Rezoning Transportation Analysis

Petition Number: 2019-173

Revision Log:

Date	Description
01-17-2020	First Review
05-20-2020	Second Review (WB)

PROPOSED GARRISON ROAD CROSS SECTIONS

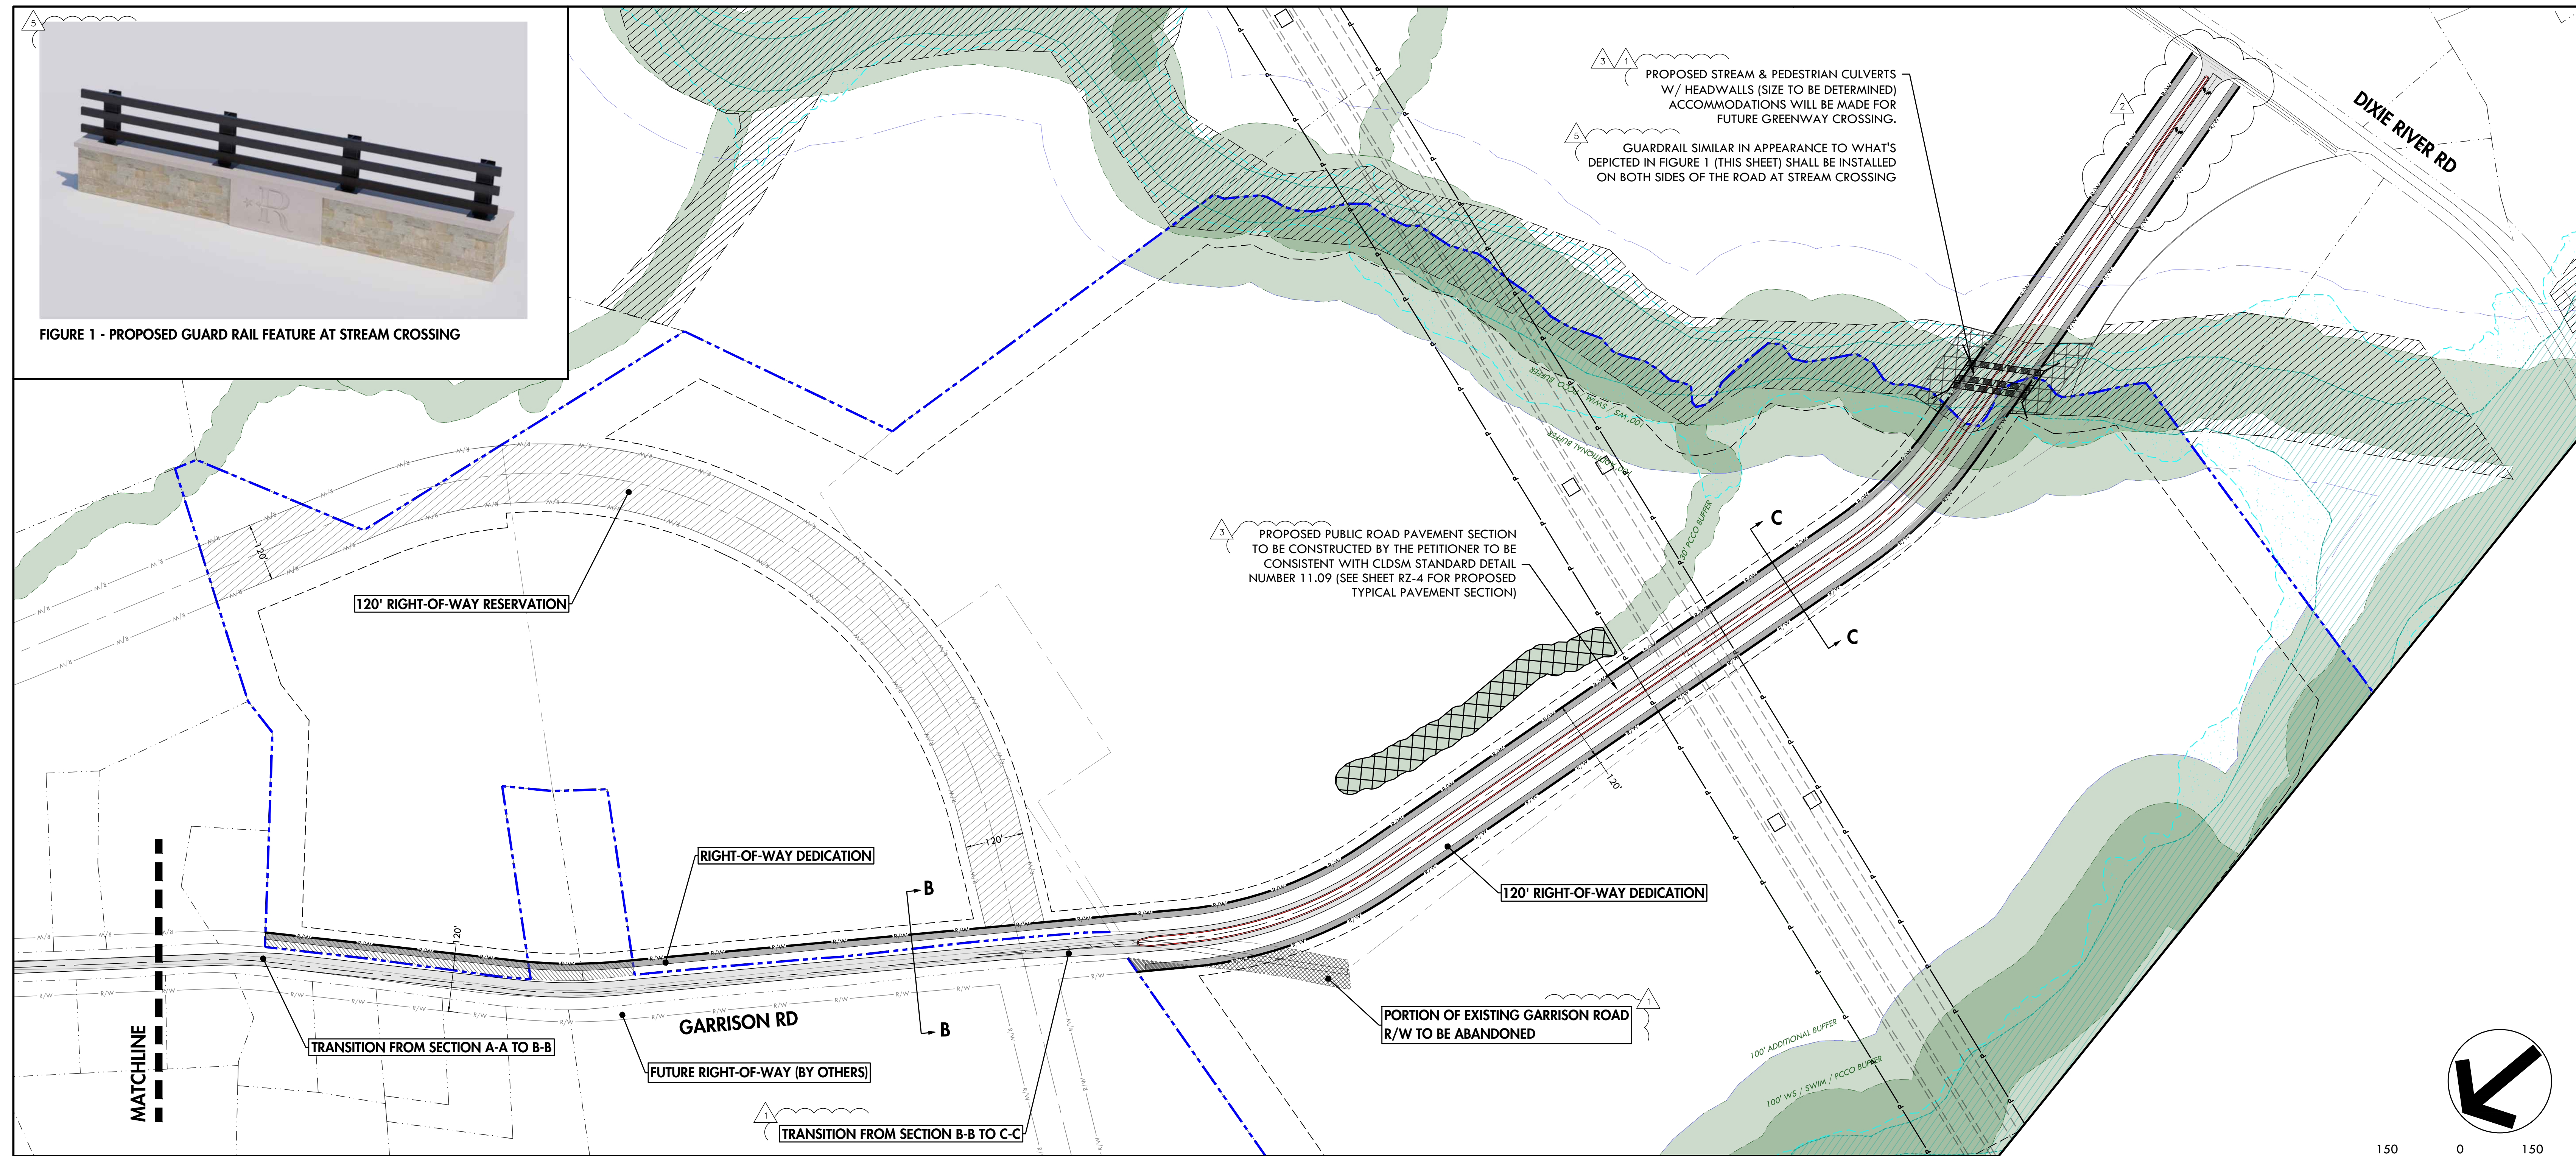
- New Comment based on revised site plan 05-11-2020:** Cross-section C-C depict the general intent of a 3-lane section (2 travel lanes and center turn lane and/or planted median) and a shared-use path for an interim version of future Garrison Road. The petitioner should revise the site plan and conditional notes to commit to construct 2' paved shoulders and 4' grass shoulders. The petitioner should add a note stating the final details will be determined during permit review process to include input from other departments including but not limited to CDOT, General Services, Charlotte Fire Department, the NCDOT. Also include that any applicable ordinance requirements in addition to what is shown on proposed cross-sections may be required.

SECTION A - A
PROPOSED ROAD IMPROVEMENTS
(FUTURE BY OTHERS)

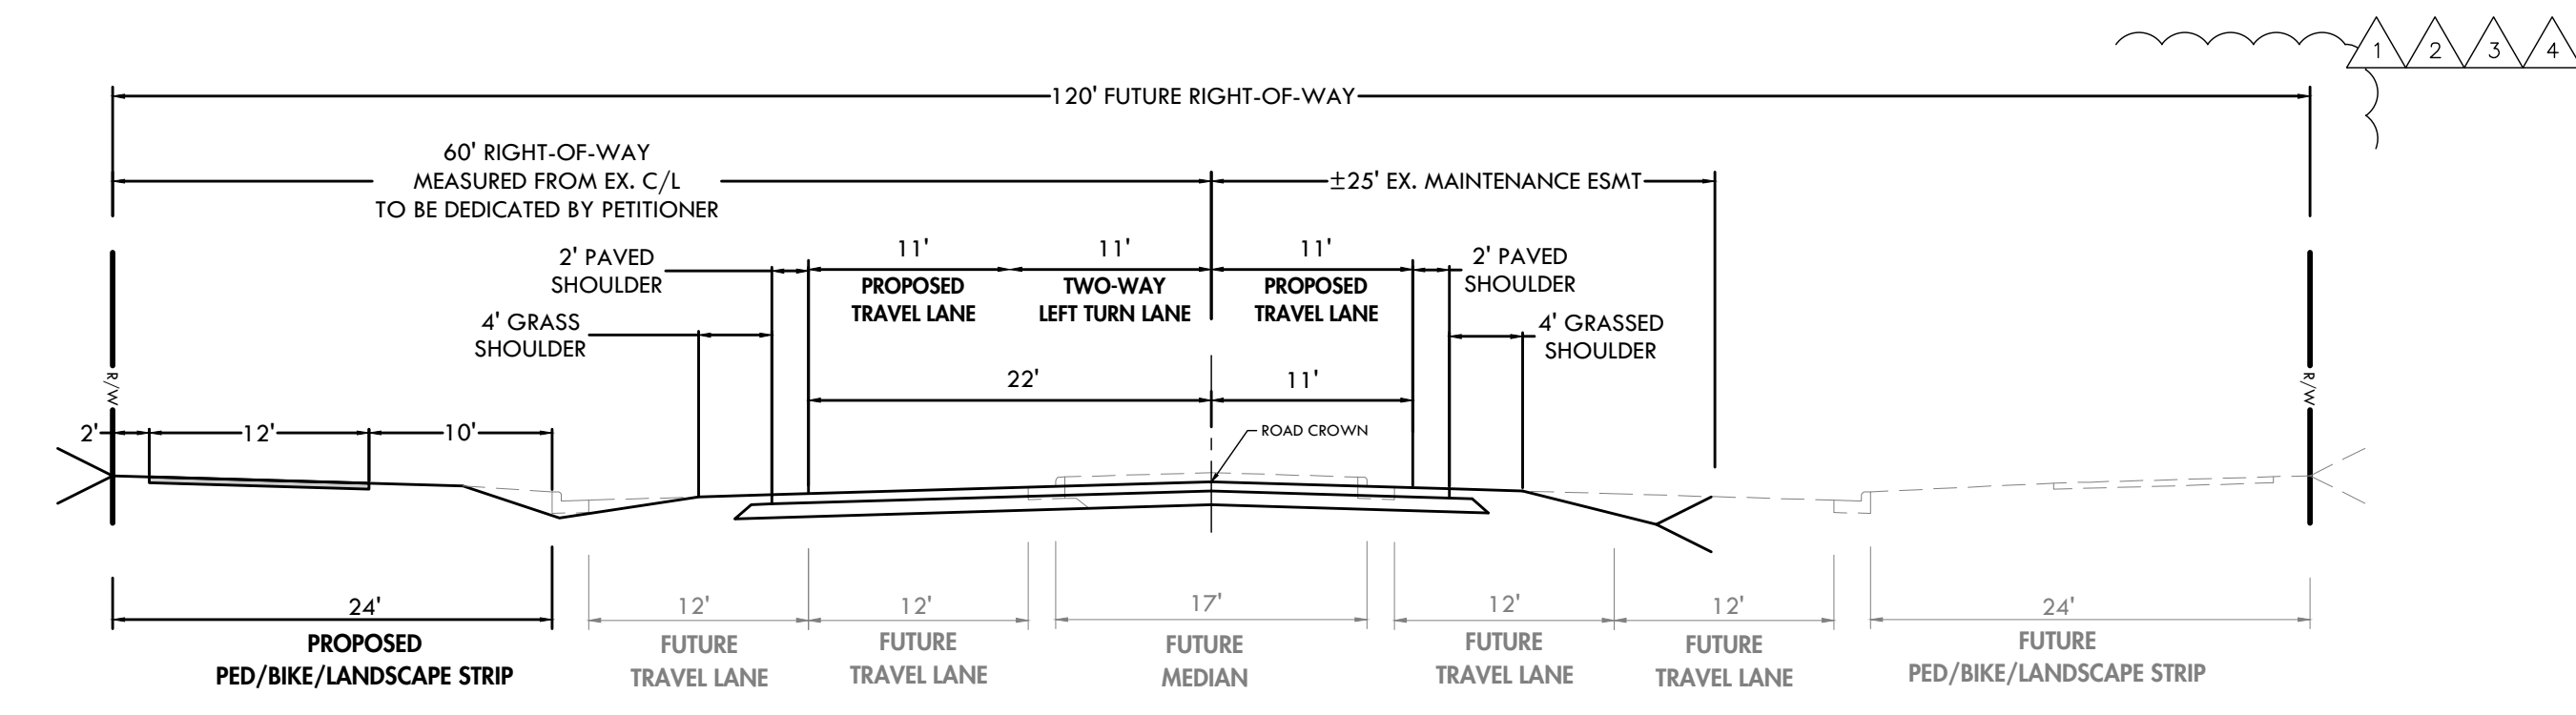
6. **New Comment based on revised site plan 05-11-2020:** The petitioner should revise the site plan and conditional notes to commit to construct 2-12' lanes with 2' paved shoulders and 4' grass shoulders. for Section A-A. The petitioner should add a note stating the final details will be determined during permit review process to include input from other departments including but not limited to CDOT, General Services, Charlotte Fire Department, the NCDOT. Also include that any applicable ordinance requirements in addition to what is shown on proposed cross-sections may be required

SECTION B - B
PROPOSED ROAD IMPROVEMENTS
(FUTURE BY OTHERS)

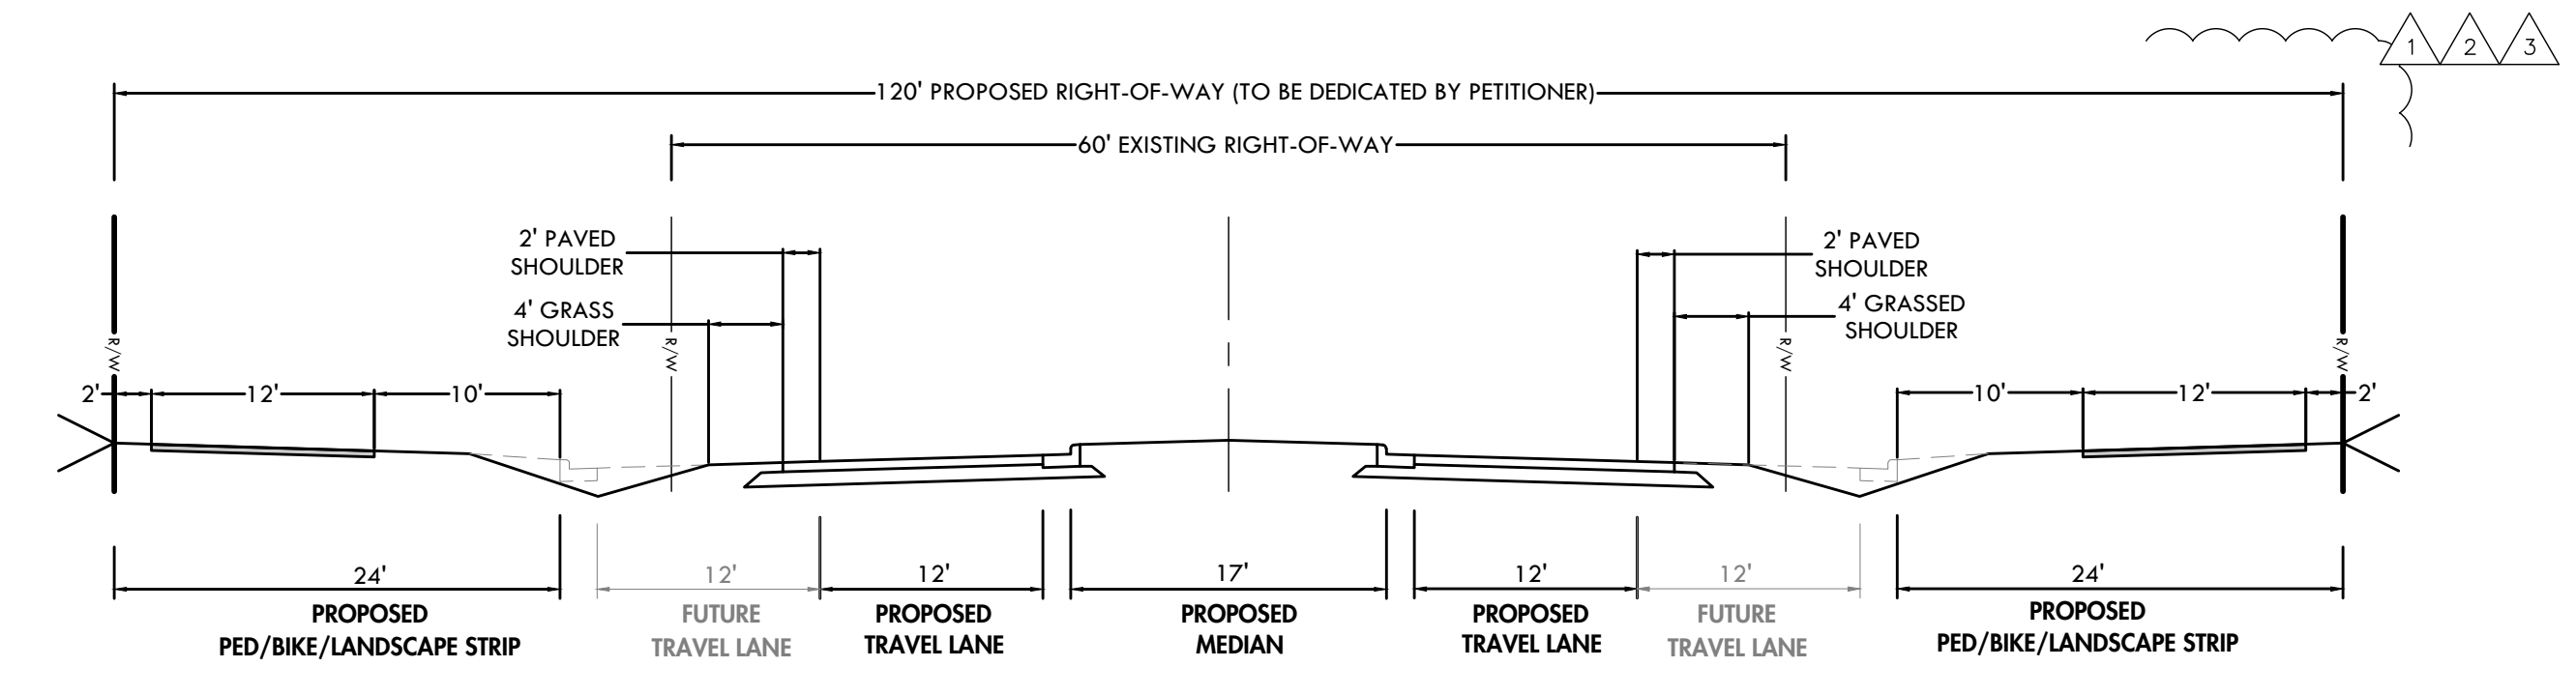
- New Comment based on revised site plan 05-11-2020:** The petitioner should revise the site plan and conditional notes to commit to construct 2-12' lanes with 2' paved shoulders and 4' grass shoulders for Section B-B. The petitioner should add a note stating the final details will be determined during permit review process to include input from other departments including but not limited to CDOT, General Services, Charlotte Fire Department, the NCDOT. Also include that any applicable ordinance requirements in addition to what is shown on proposed cross-sections may be required
